22 June 2020

Your Ref: SSI 10041
Our Ref: R/2019/23/A
File No: 2020/254596

New Request for Advice - Redfern Station Upgrade - New Southern Concourse

Figure 5-3 Indicative cross section – Little Eveleigh Street and Marian Street shared zones

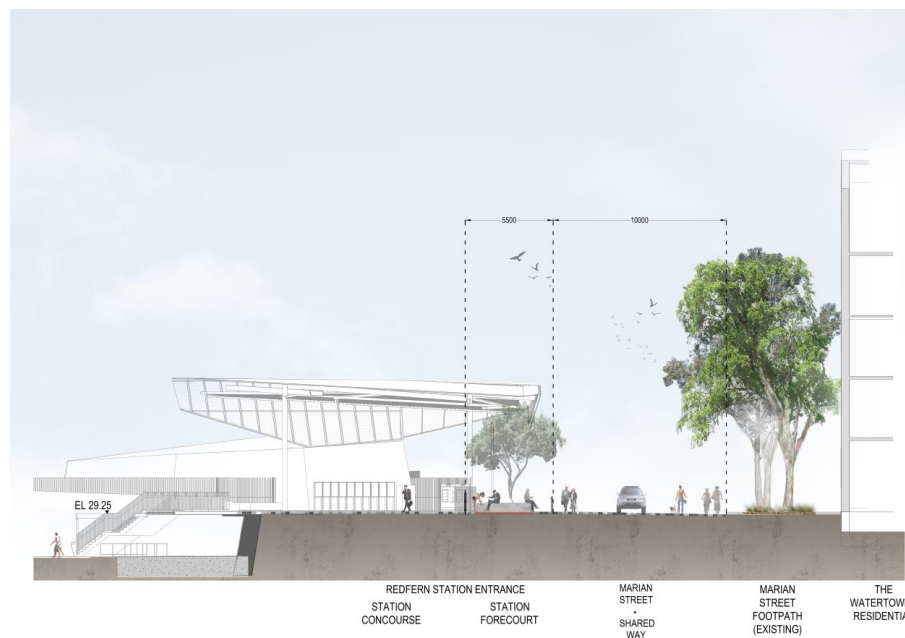
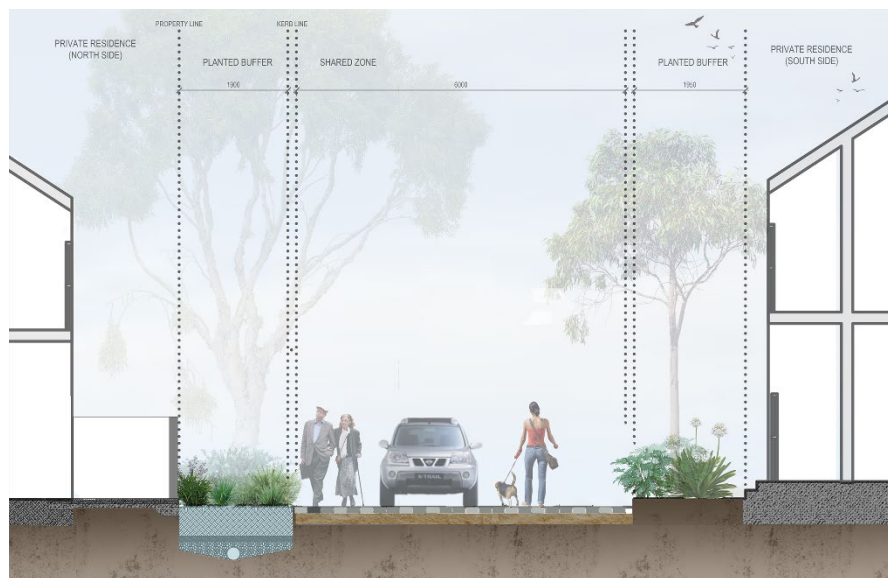
As discussed in Section 3 above, the introduction of a shared zone along Little Eveleigh Street will enhance pedestrian and cyclist experience. It is noted that the existing dedicated cycling path has proposed to be removed as part of formalising the shared zone. The City welcomes discussions to modify the existing street conditions through separate consultation and referral to the LPCTCC for endorsement. Additional reports, information or design changes may be required by City or the LPCTCC. The cost of any changes and associated documentation are to be undertaken by the applicant. The plan is to be approved as part of the Public Domain Plan and prior to commencement of any public domain work.
